Recommendation Report for Planning Permission for Works or Extension to a Dwelling

REF NO: EP/68/26/HH

LOCATION: 8 Tamarisk Way
East Preston
BN16 2TF

PROPOSAL: Two storey front extension. New windows. New cladding to the first floor.

Proposed Elevations

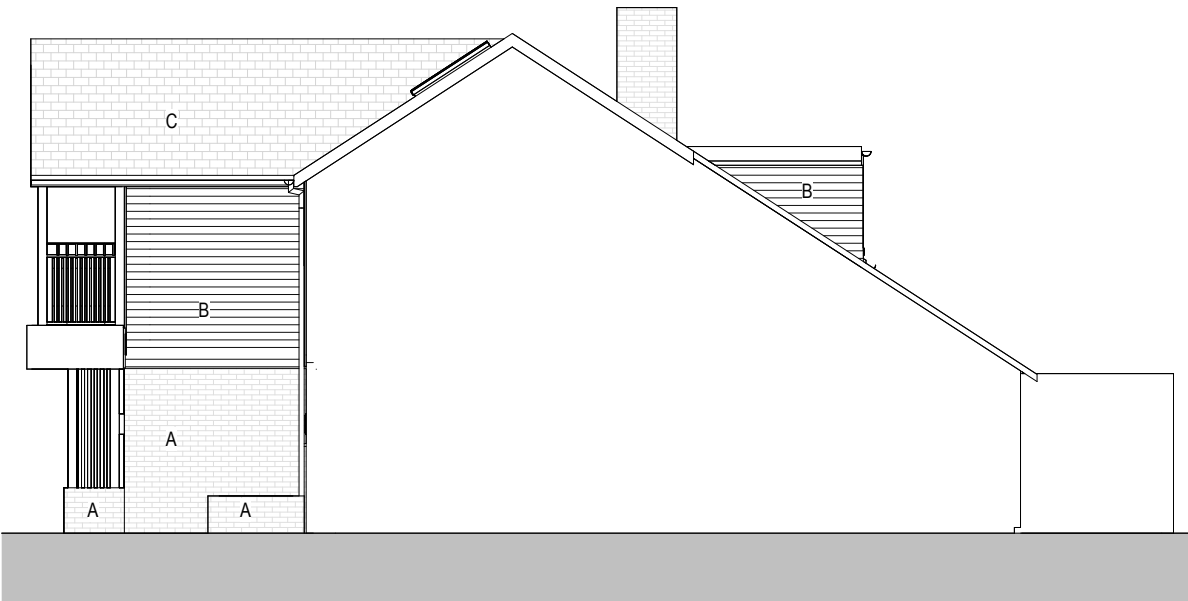
Middleton Parish Council raised no objection. However, the committee expressed concern that the application did not provide details of the roof tile colour or the balcony railings.

The proposed two-storey front extension would be centrally positioned and would create a more prominent entrance feature, with the first-floor balcony adding emphasis to the entrance. The extension would have a width of 4.95m and a depth of 3.65m. This would exceed the depth guidance for front extensions set out in Part M of the Arun Design Guide (ADG). At first-floor level, the extension would include a terrace and balcony within the proposed 3.65m projection. The works would replace the existing single-storey porch and increase its footprint.

The extension would have a gable-ended roof set approximately 0.1m below the ridge of the host dwelling, with an overall height of approximately 6.5m and an eaves height of approximately 4.65m. Although the extension would exceed the 1.5m depth guidance in the ADG and would not appear subservient, there are comparable examples within the vicinity. The dwelling is set back from the highway, and the staggered building line would further reduce its visual prominence. The extension would not project beyond the predominant building line or extend the full width of the building, avoiding a visually harmful or 'bolt-on' appearance. Therefore, the extension would not appear incongruous or unduly prominent within the street scene and its scale, sizing and integration with the host dwelling would not result in unacceptable visual harm to amenity.

On the front southern elevation at first-floor level, the extension would include double doors with narrow full-height windows on either side, providing access to the balcony, together with a rooflight in the southern roof slope. On the rear northern elevation, the proposal would not increase the number of openings. Obscure glazing would be installed to one ground-floor window, and two first-floor windows serving bathrooms and an en-suite. At ground-floor level, on the western flank, the existing large two-panel sliding door would be replaced with a three-casement window, while on the side western elevation, the porch window would be reduced in size. On the side eastern elevation, the ground-floor porch door would be removed. All fenestration would be replaced with white uPVC.

The proposed balcony would have a depth of 0.9m, a width of 5m and a height of 1m. The balustrade would be finished in white aluminium and timber bars for both the posts and railings. This finish would be consistent with the wider palette of white external materials proposed for the dwelling and would not result in harm to visual amenity.

These concerns are noted. The roof tiles would match the existing dwelling and the balcony railings would white aluminium and timber bars for both the posts and railings.

Proposed Elevations

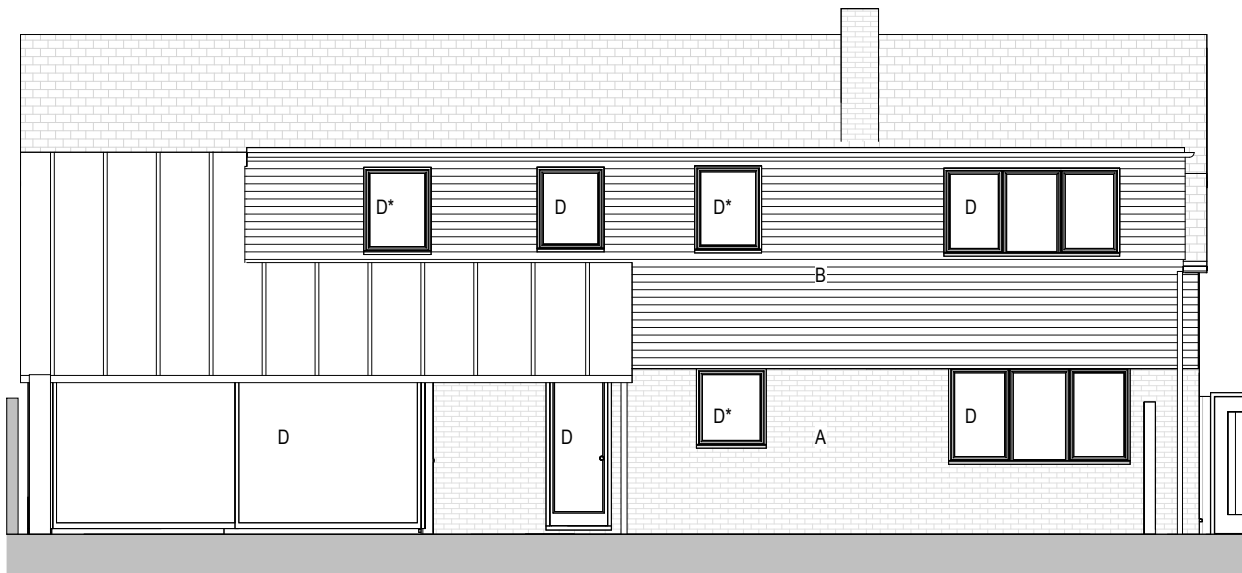
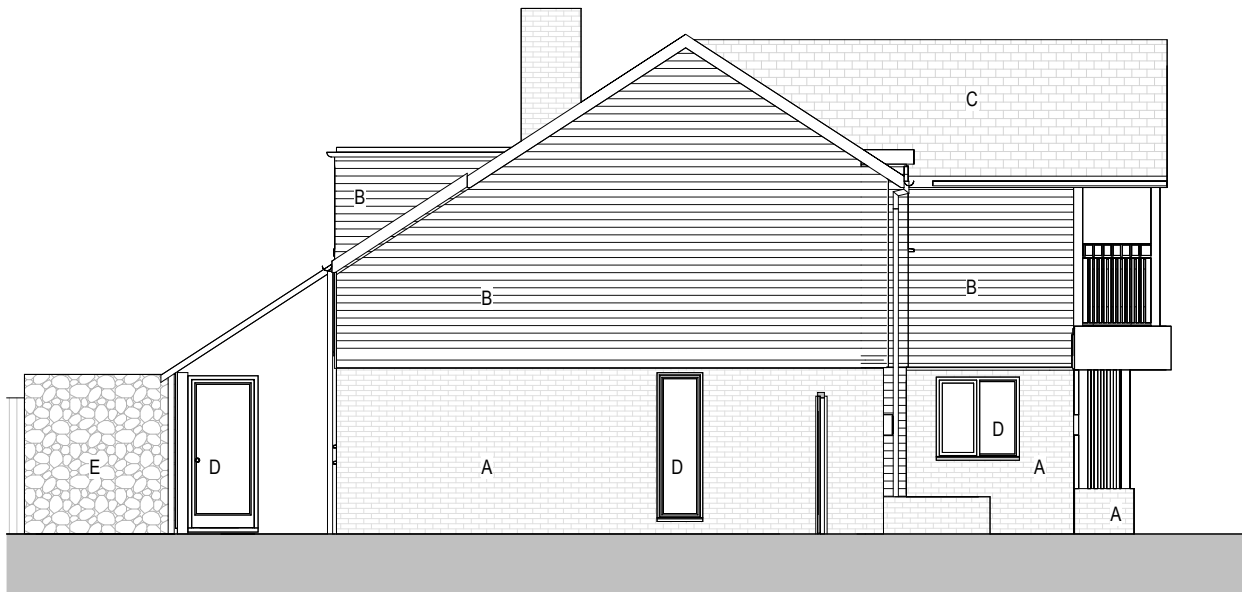
1 No. letter of no objection was received. The comments requested that the replacement first-floor windows on the northern side elevation remain the same size as existing and are not enlarged or altered to form Juliet balconies.

locality. The use of white external finishes would also reflect the appearance of nearby dwellings. On the northern elevation, stone cladding would be applied to a wall on the eastern flank projecting from the rear of the dwelling.

The proposal does not include Juliette balconies. The windows would not be increased in size, and obscure glazing would be used for windows serving a bathroom and an en-suite.
